23 January 2018

Re: Development Application SSD 8373 – Alexandria Park Community School Redevelopment, Park Road, Alexandria 2015

AR.DA. 5002

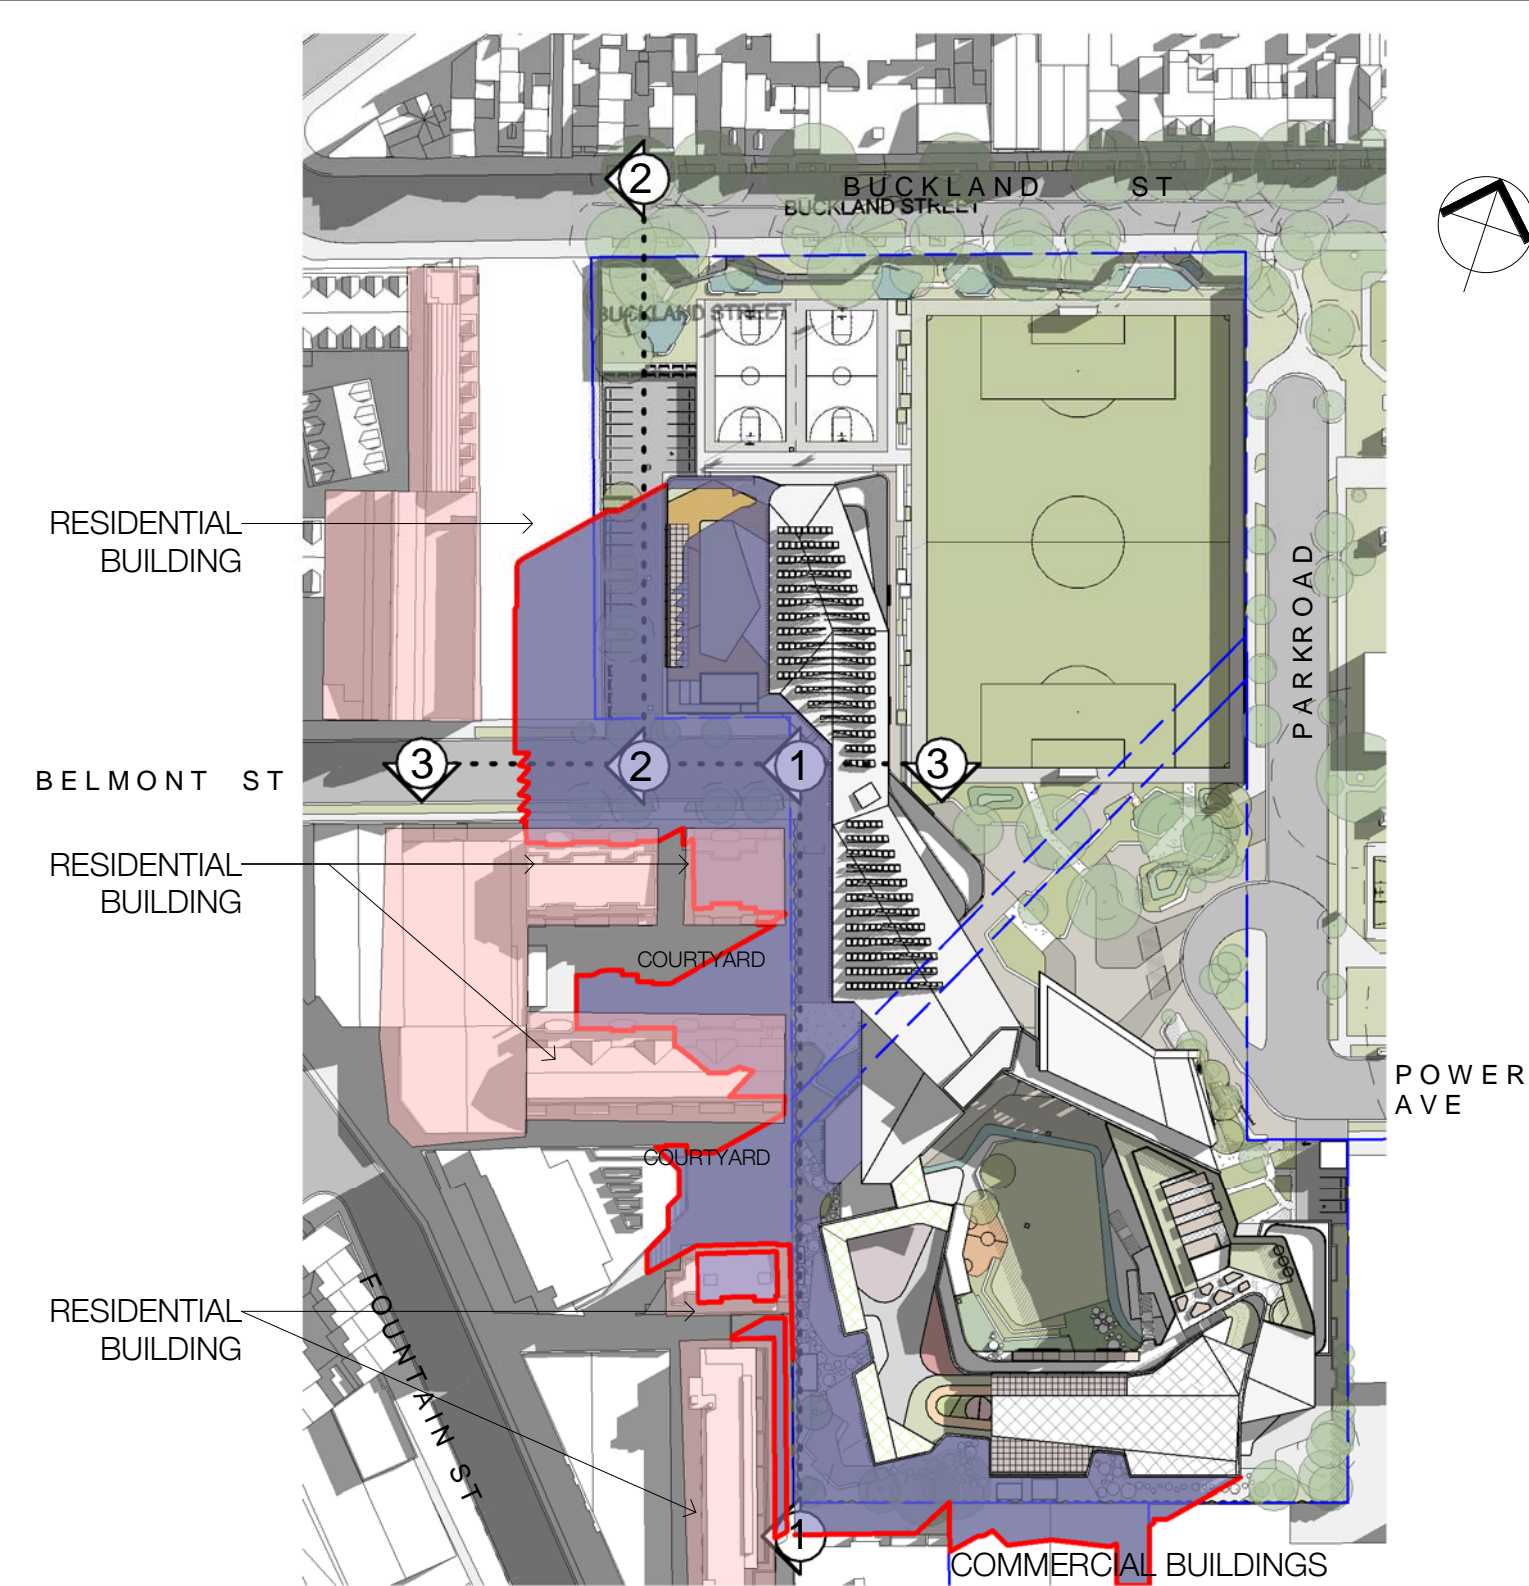
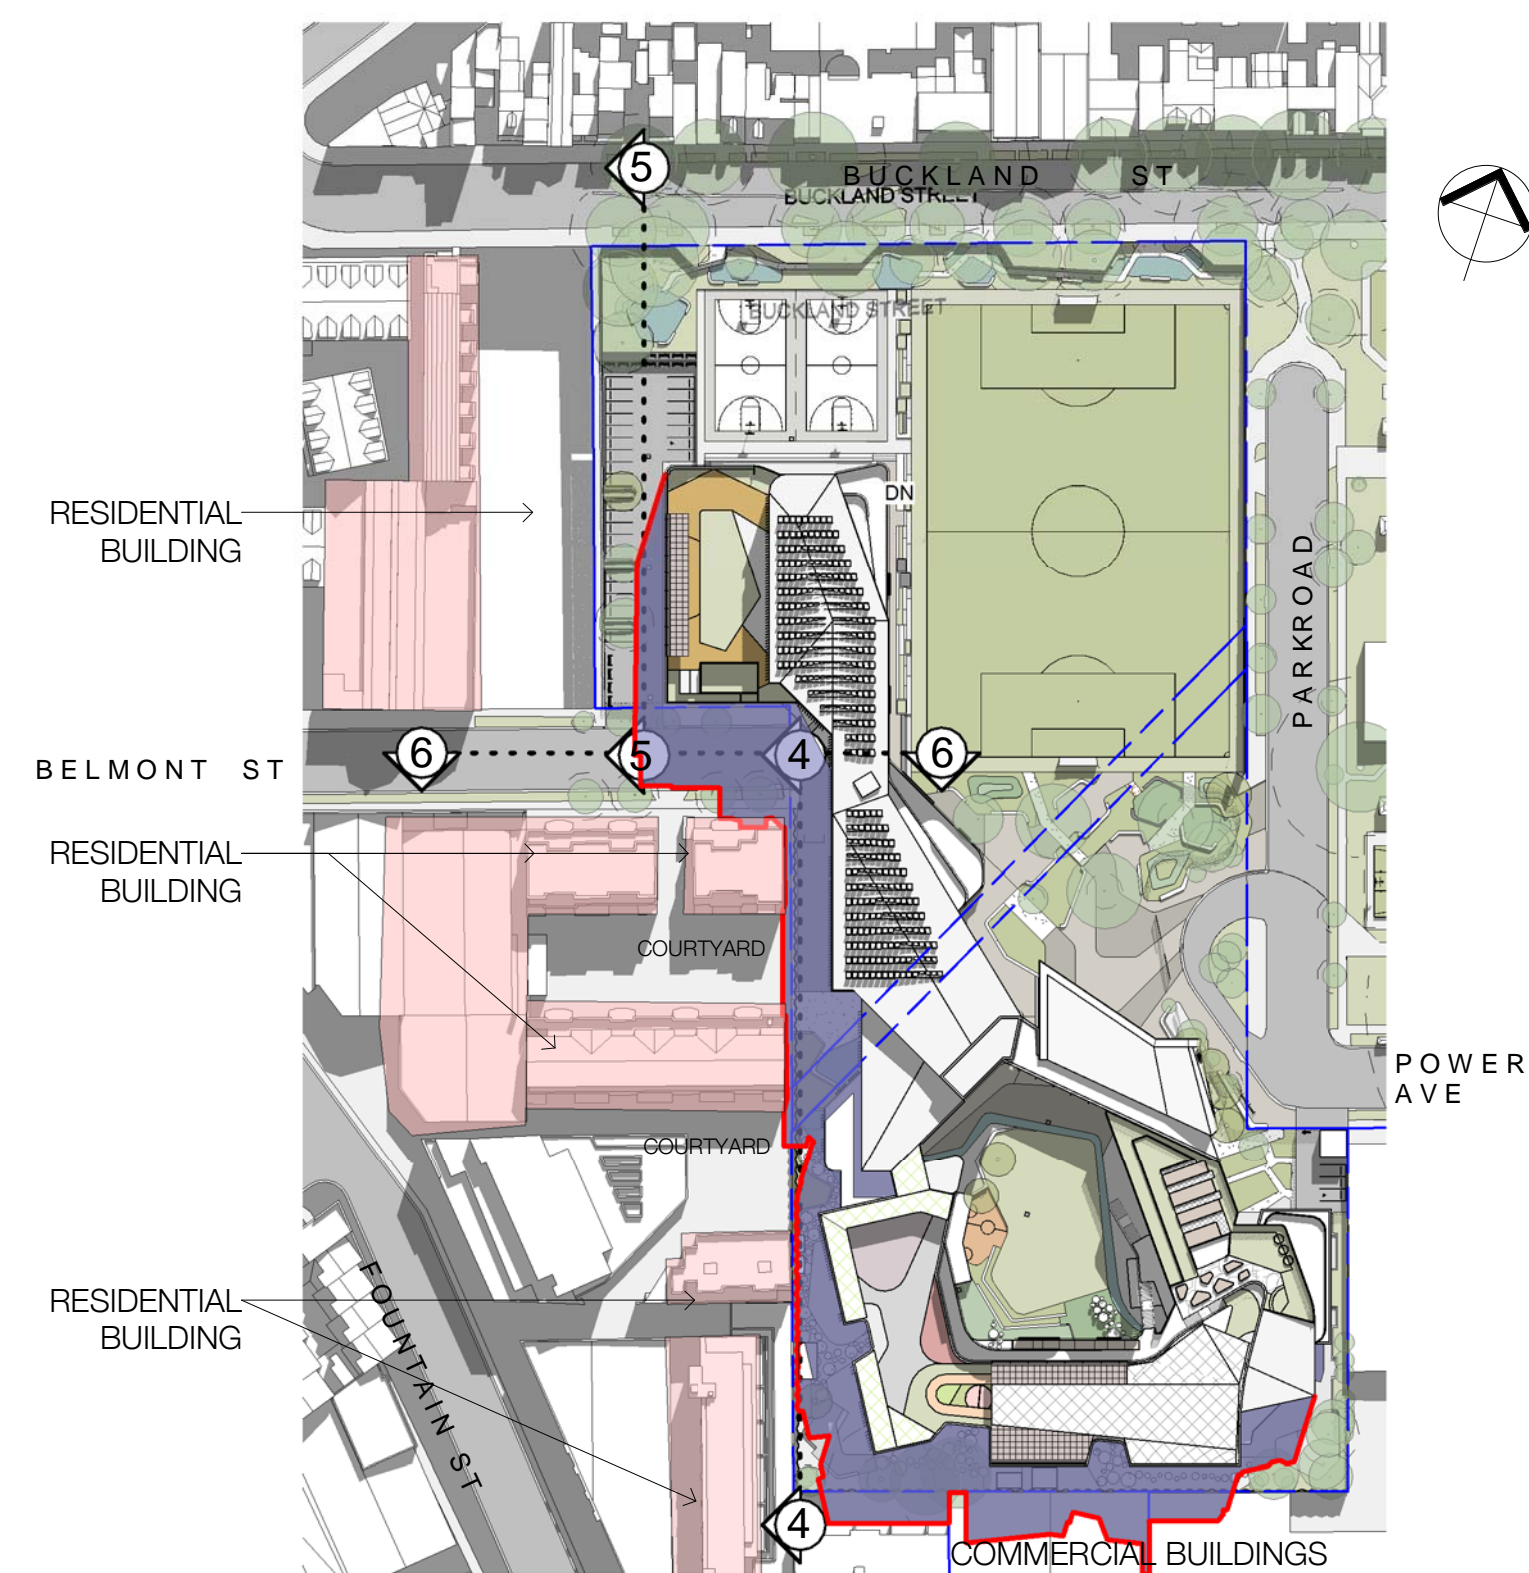
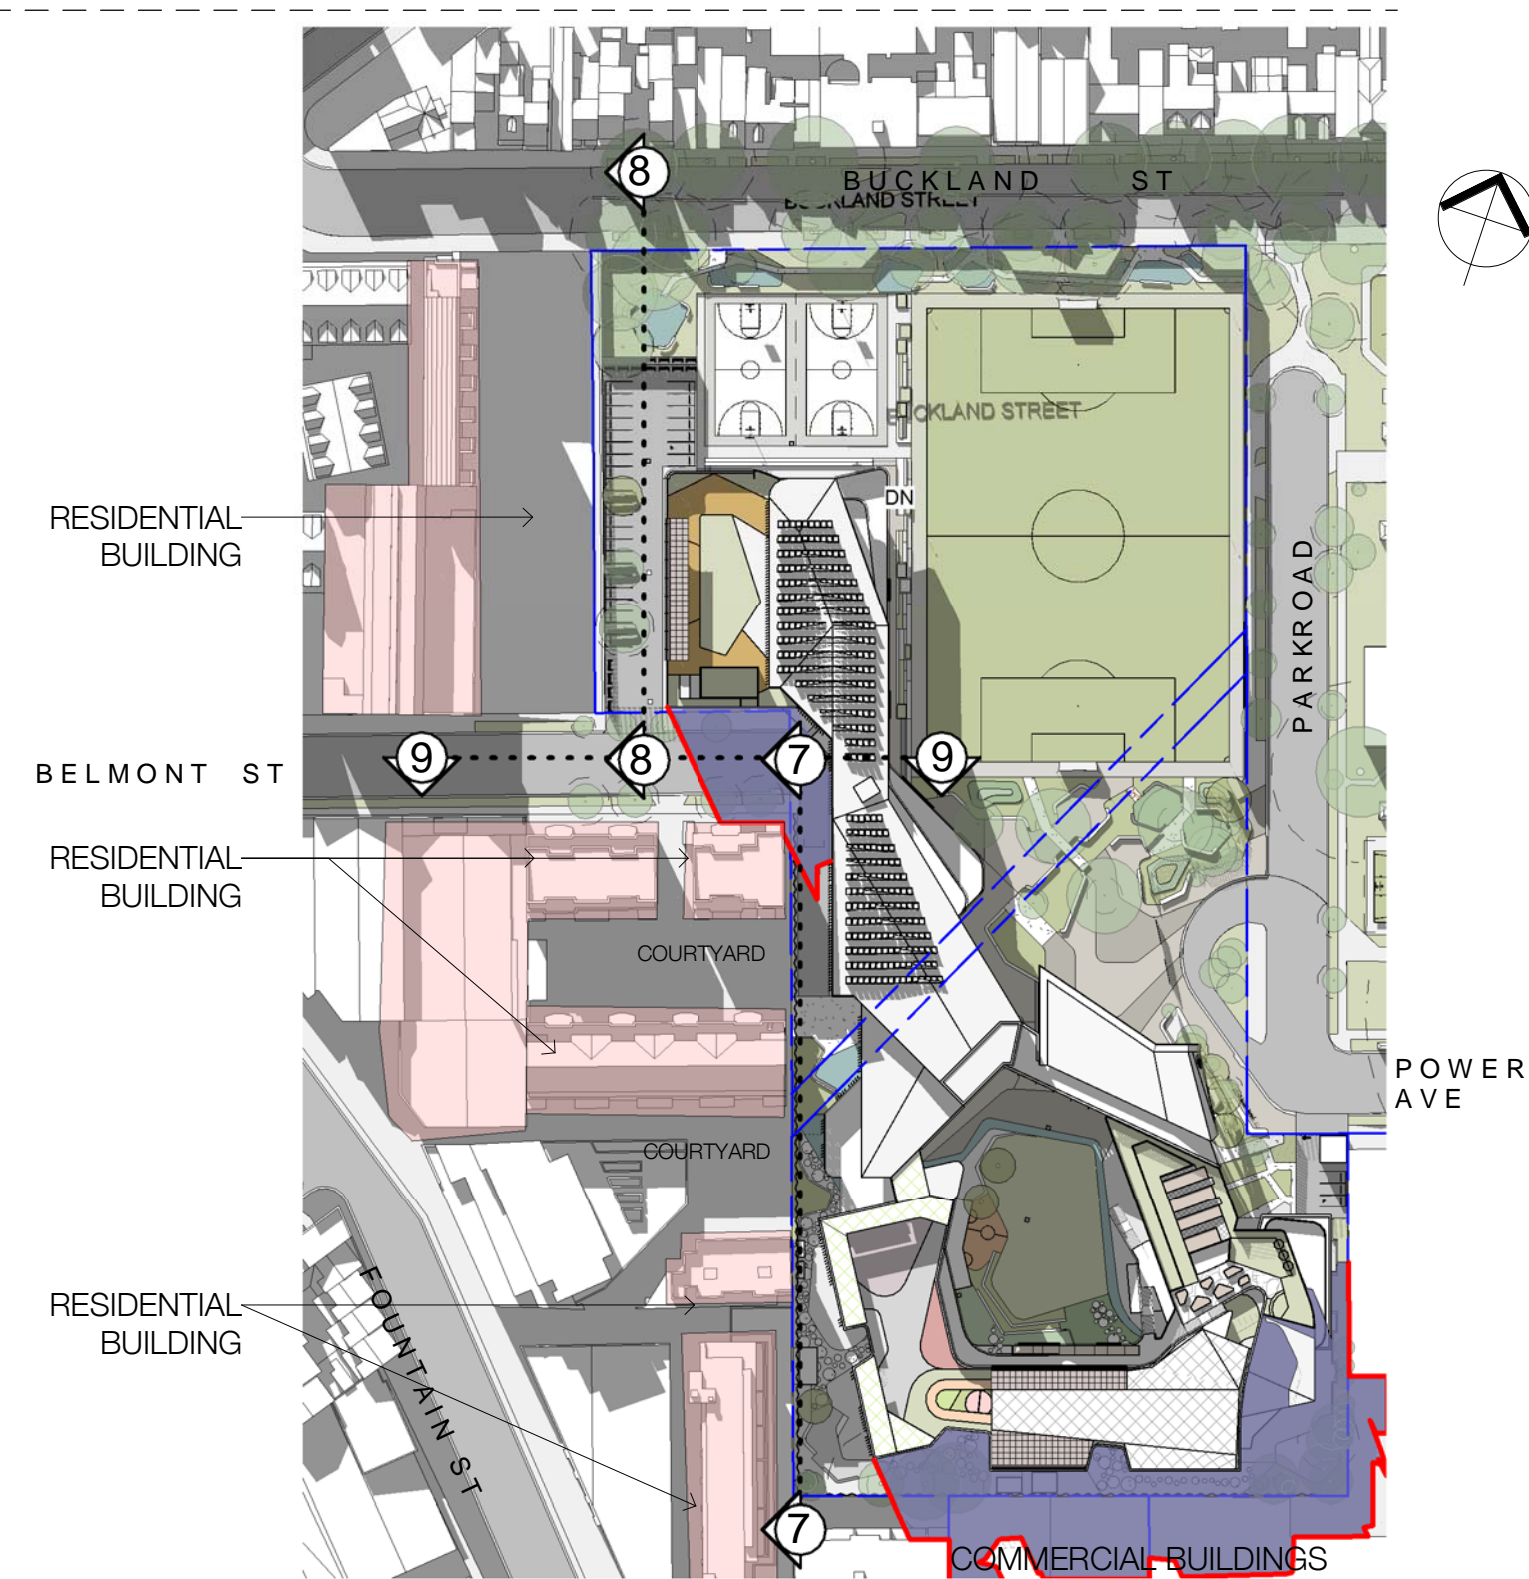
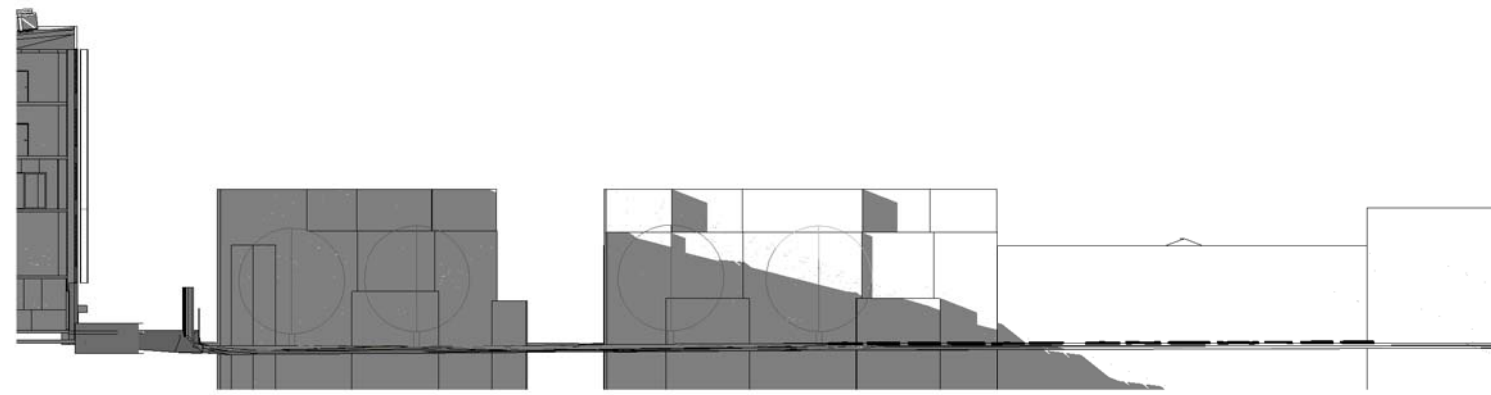
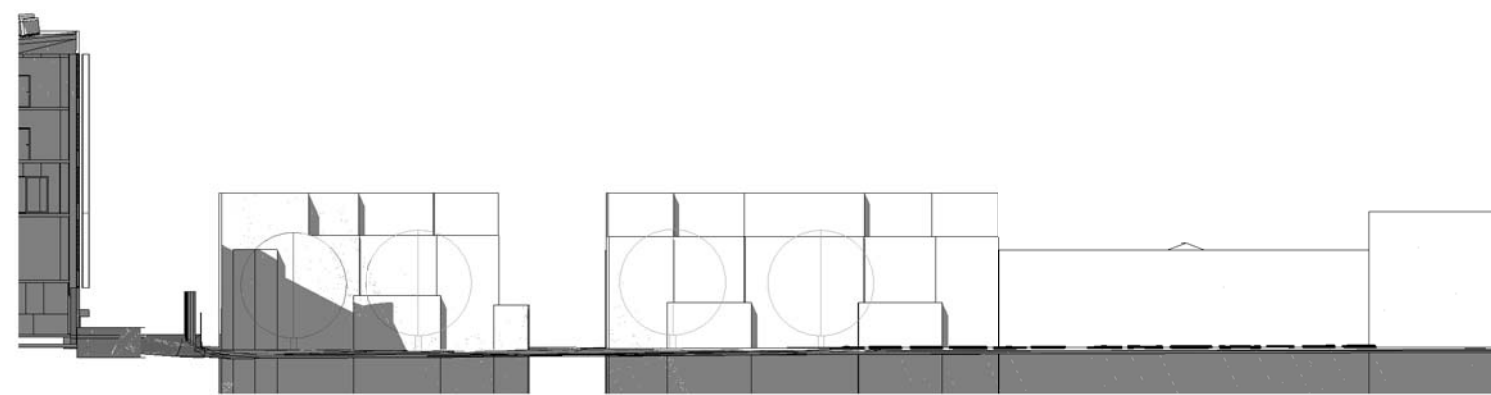
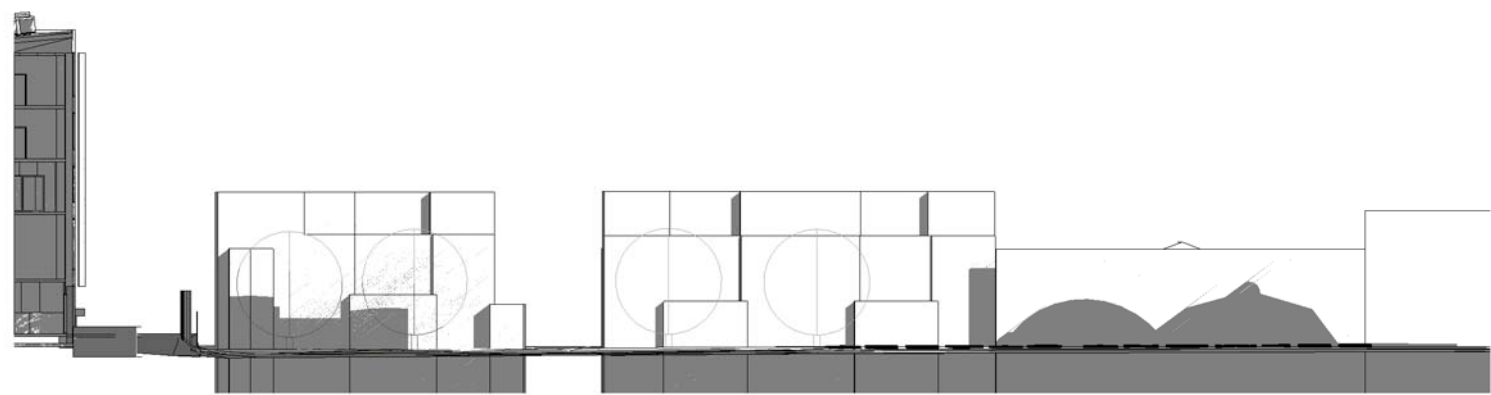
The 15 units in 141-143 McEvoy Street on the southern boundary all have living areas & outdoor areas facing north. The shadow diagrams on DA5002 do not even show this as a residential building.

In addition, there are **no shadow elevational diagrams** at all on Drawing No. AR.DA.5002 P1 for 141-143 McEvoy Street which is a residential property & therefore as my understanding is, is required to be taken into consideration.

The shadow plans show that the southern properties will have all sunlight removed at ground level. There are no shadow diagrams showing the impact on the mid & upper balconies & living areas.

We seek evidence of solar access to all 15 units of 4 hours between 9-3 at Winter Solstice. This could be achieved by means of increased boundary set back and/or lowering the height of the proposed development.
